Our ref: OUT23/85

**Subject: Sydney Olympic Park Metro Station – Over & Adjacent Station Development (SSD-35283699)
Environmental Assessment**

Detailed advice to DPE Planning & Assessment regarding the Sydney Olympic Park Metro Station Development (SSD-35283699)

**Figure 3-5 Baseline groundwater conditions showing drawdown due to inflow to the drained station box (Drawdown caused by the rail loop is not shown)**

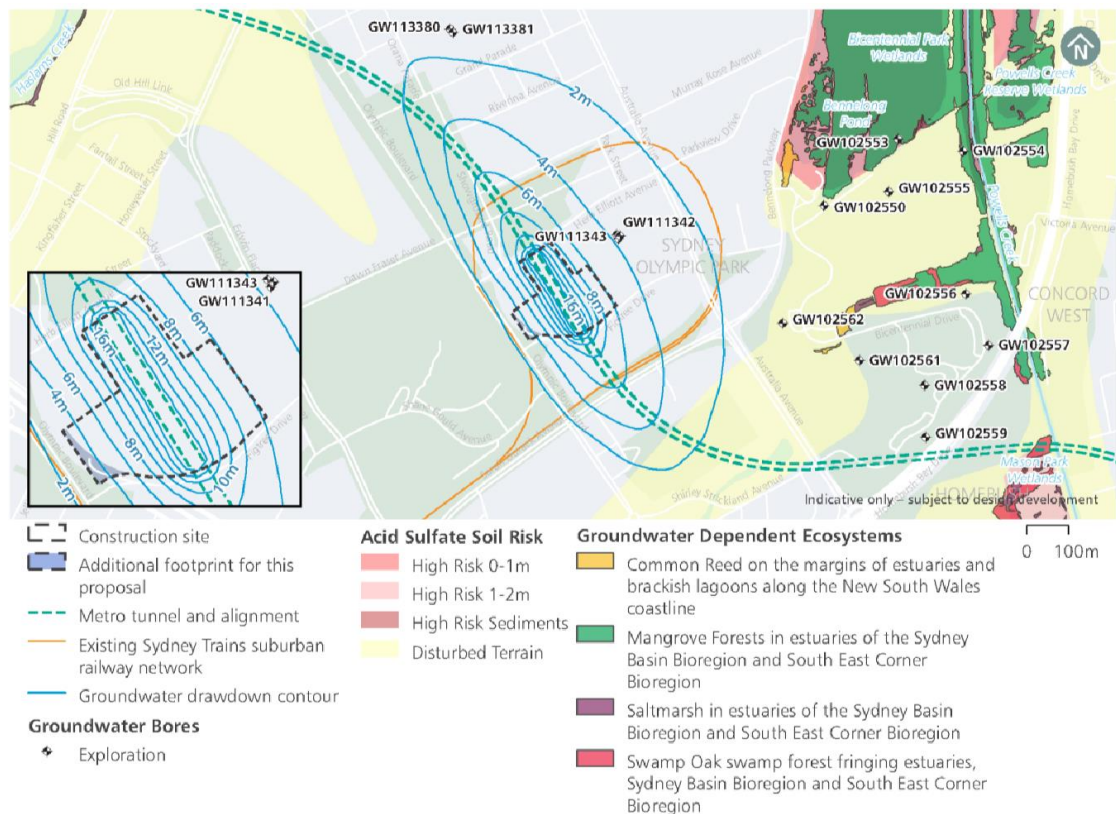
The EIS for the Concept State Significant Development application does not provide enough information to understand the impacts to groundwater. The geotechnical report provides a short summary of previous reporting and concludes that the box and tunnel will likely underdrain the basement. Given the lack of current detailed design, modelled drawdown for additional structures and impact assessment, it is unclear whether the addition of the basement levels as a drained structure would cause more than minimal impacts to groundwater.

DPE Water recommends that the EIS for the final detailed design include an assessment against the Aquifer Interference Policy (2012). This assessment should consider the additional cumulative impacts of the drained basement against the Minimal Impact Considerations for Aquifer Interference Activities in table 1 of the Aquifer Interference Policy (2012). If impacts exceed the minimal impact considerations a tanked basement should be adopted.

That the proponent ensures that the EIS for the final detailed design of the basement levels includes an assessment against the Aquifer Interference Policy (2012), and if impacts exceed the minimal impact considerations that a tanked basement is adopted.
